CITY OF ALBUQUERQUE

June 29, 2018

RE: **Los Pastores Shopping Center
Montgomery/Wyoming
Revised Drainage Report
Engineers Stamp Date: 6/11/2018
Hydrology File: F19D013C**

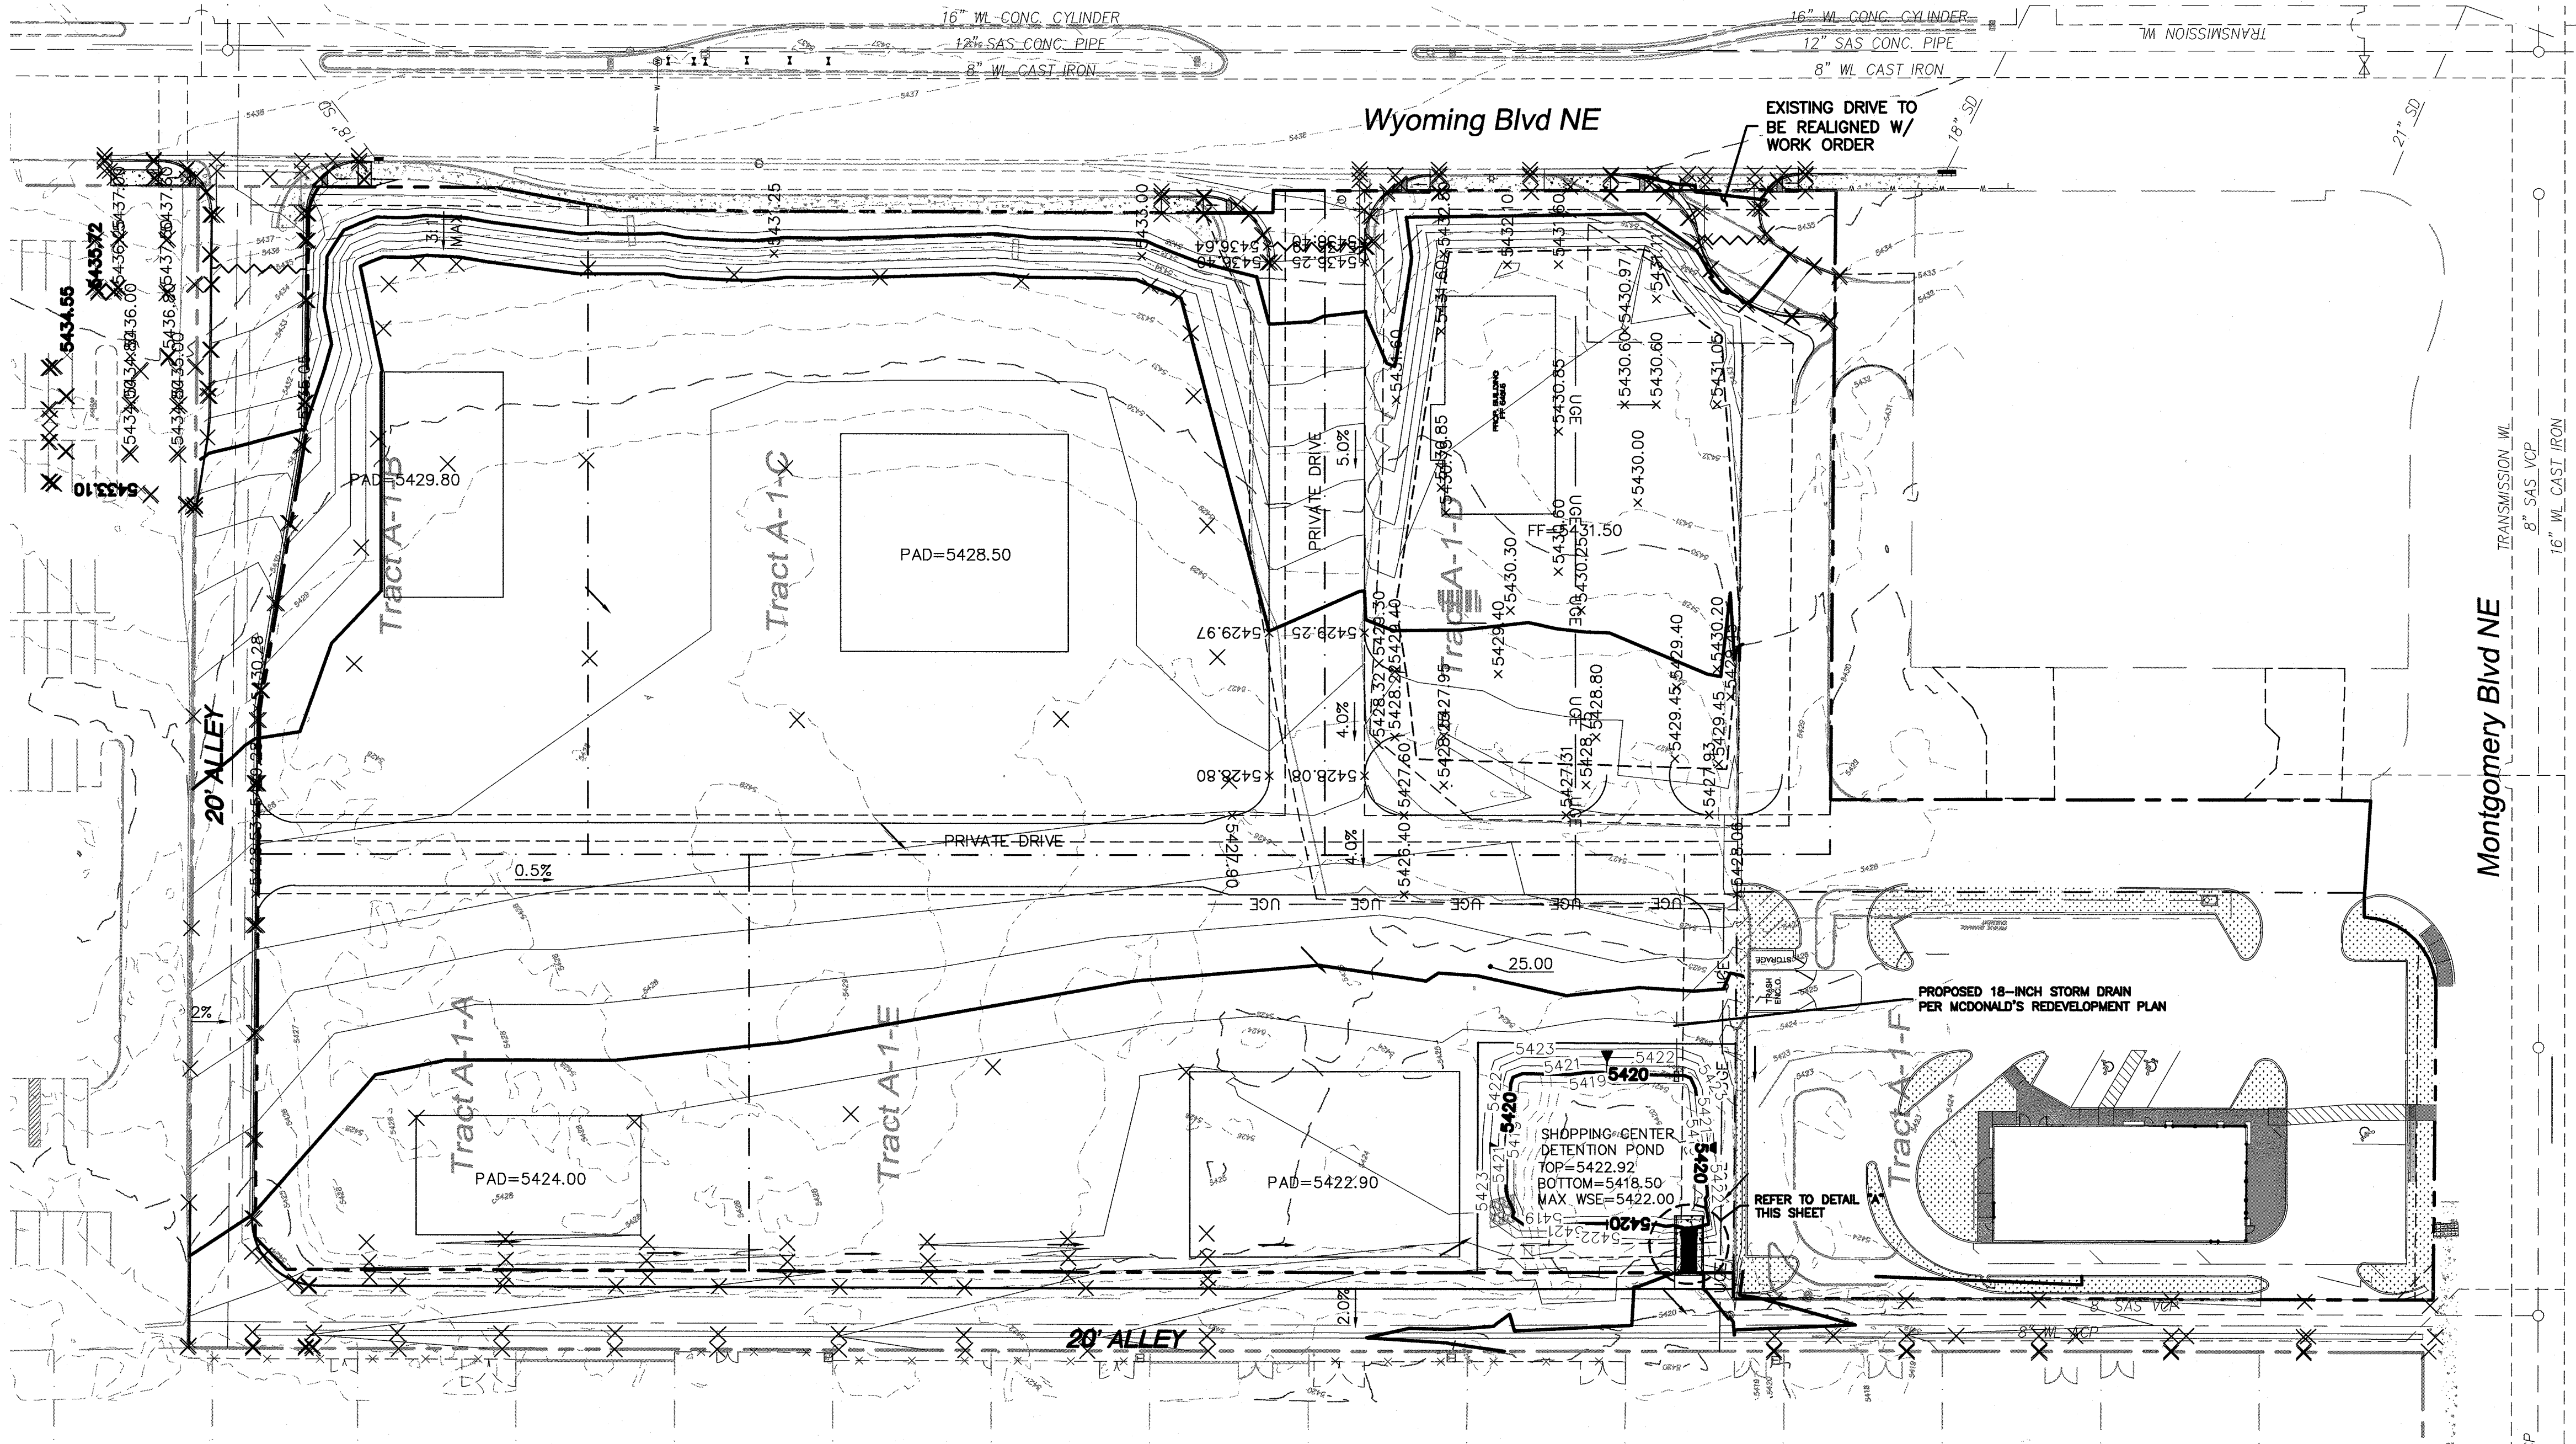
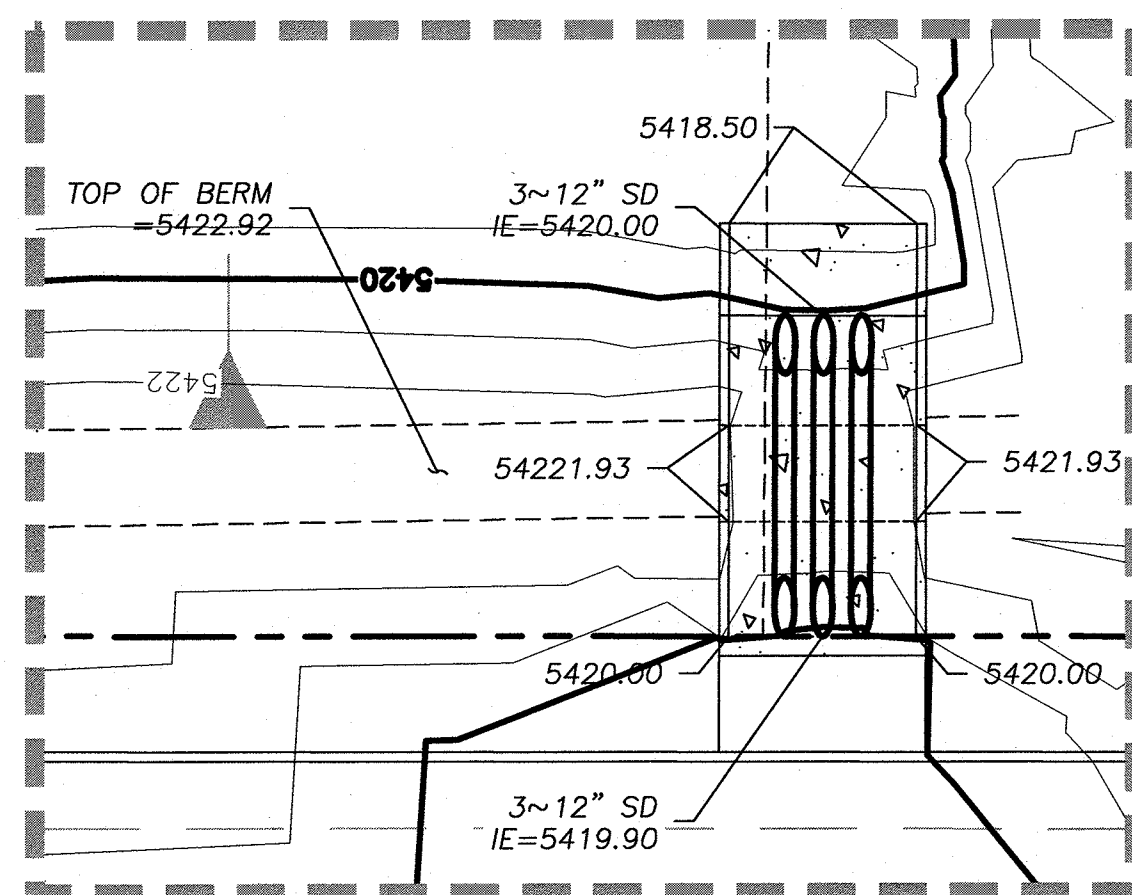
1. Permanent Public Easements must be recorded to contain the curbs, drive pads, and any necessary grading on the private residential lots west of the alley.
2. An Agreement and covenant must be recorded for maintenance of the curbs, drive pads, and grading on the lots west of the alley.
3. A Drainage Covenant is required for the maintenance of the storm water quality/detention pond.
